Approval of details reserved by condition imposed under ref AL/136/17/PL relating to Condition Nos 3 - surface water drainage, 4 - site set up during construction and 5 - vehicle wheel-cleaning facility.

Land West of Fontwell Avenue 1 Fontwell Avenue Eastergate PO20 3RU

Arun District Council have decided to **REFUSE details reserved by condition for the following reasons:**

PROPOSED SITE PLAN PURSUANT TO CONDITION 3
SCALE 1:200

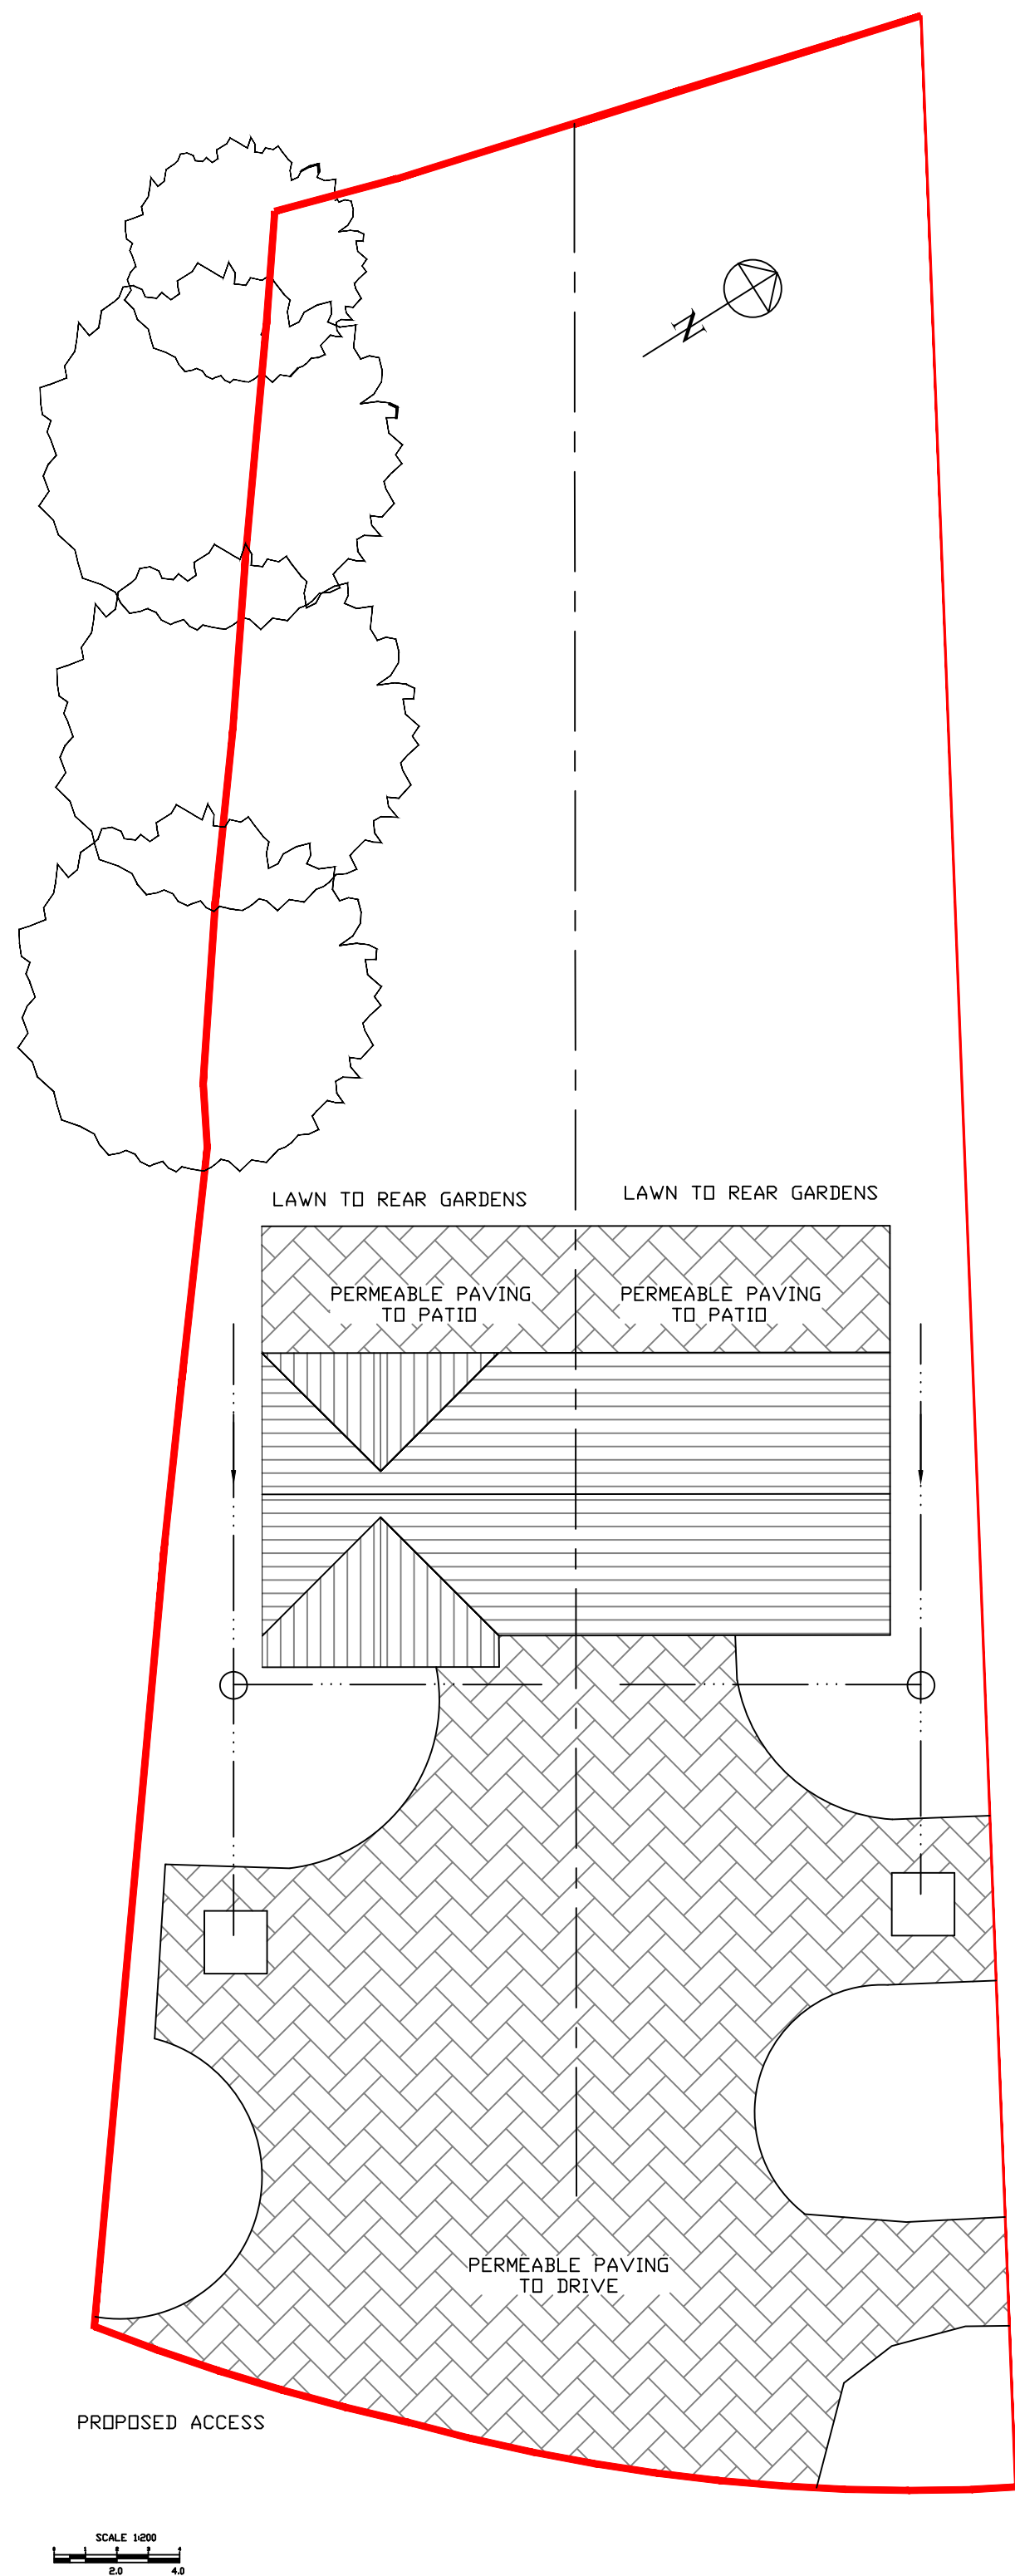
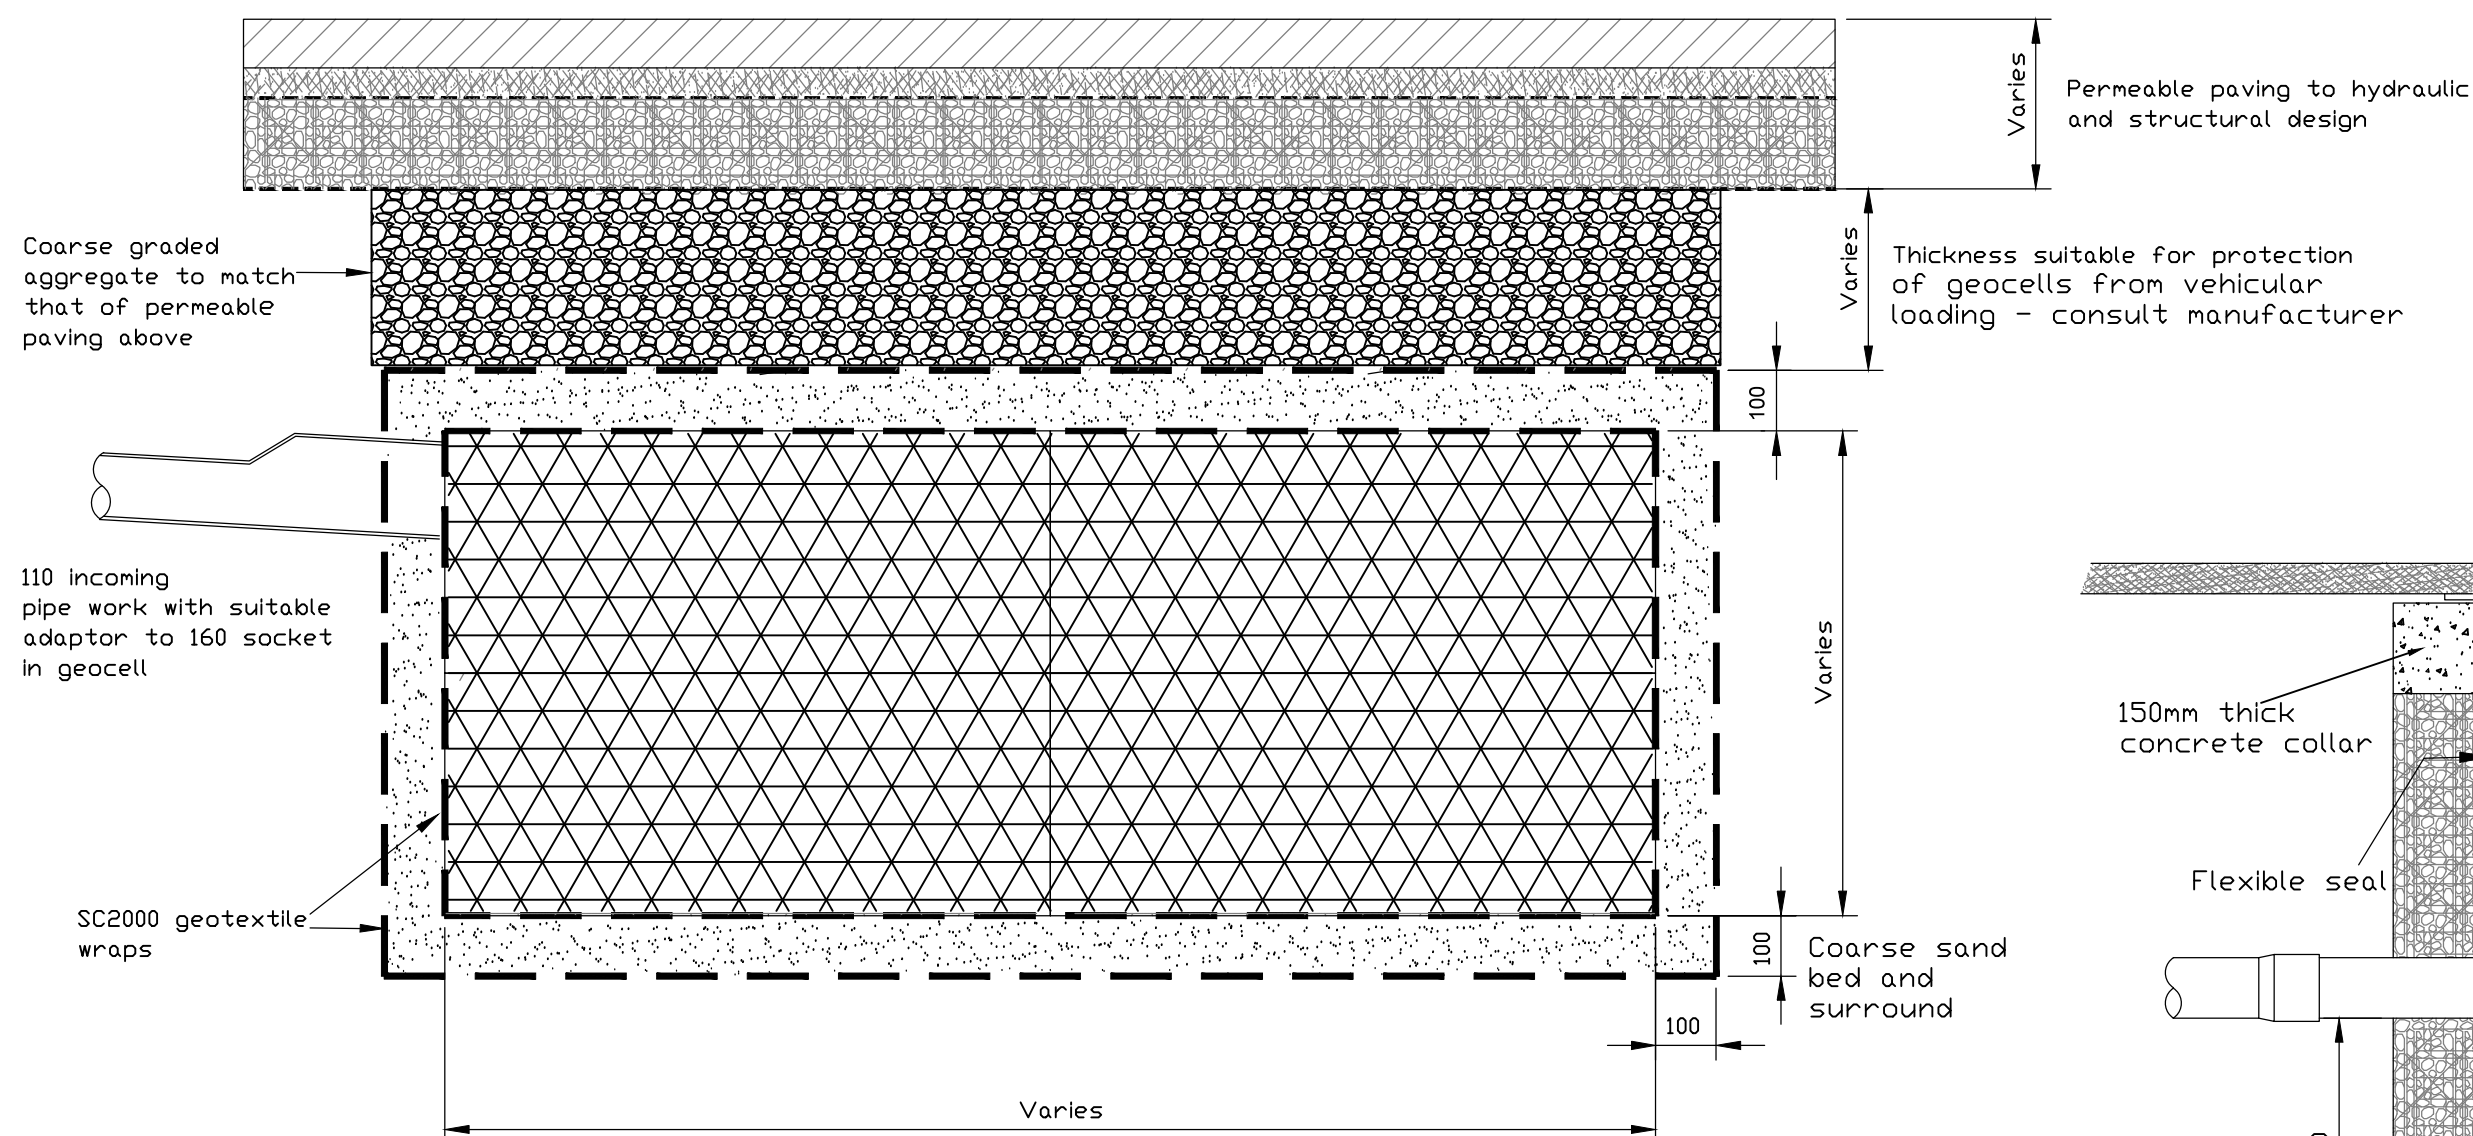
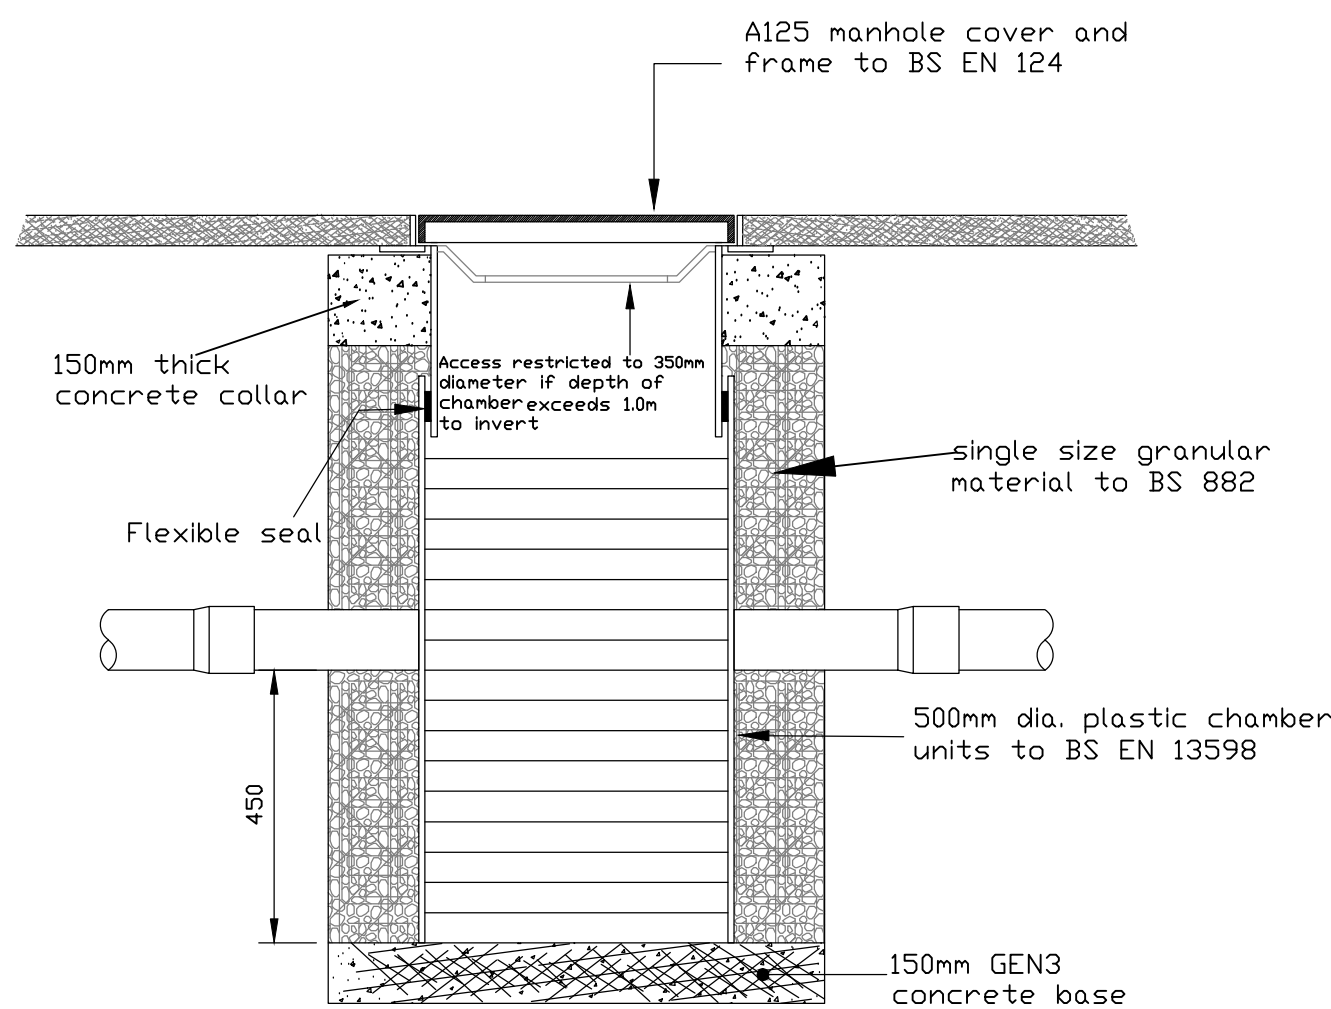
The Council's Drainage Engineers objected to the discharge of the condition on the grounds as there are several points which require resolving prior to discharge (consultation response dated 31/08/21).

Further information has been required by Drainage Engineers on 28/07/21 which were provided by applicant, however the consultation response dated 31/08/21 indicates a requirement for further details and information to be addressed.

For the above reason the condition 3 cannot be discharged and you will need to make a revised submission.
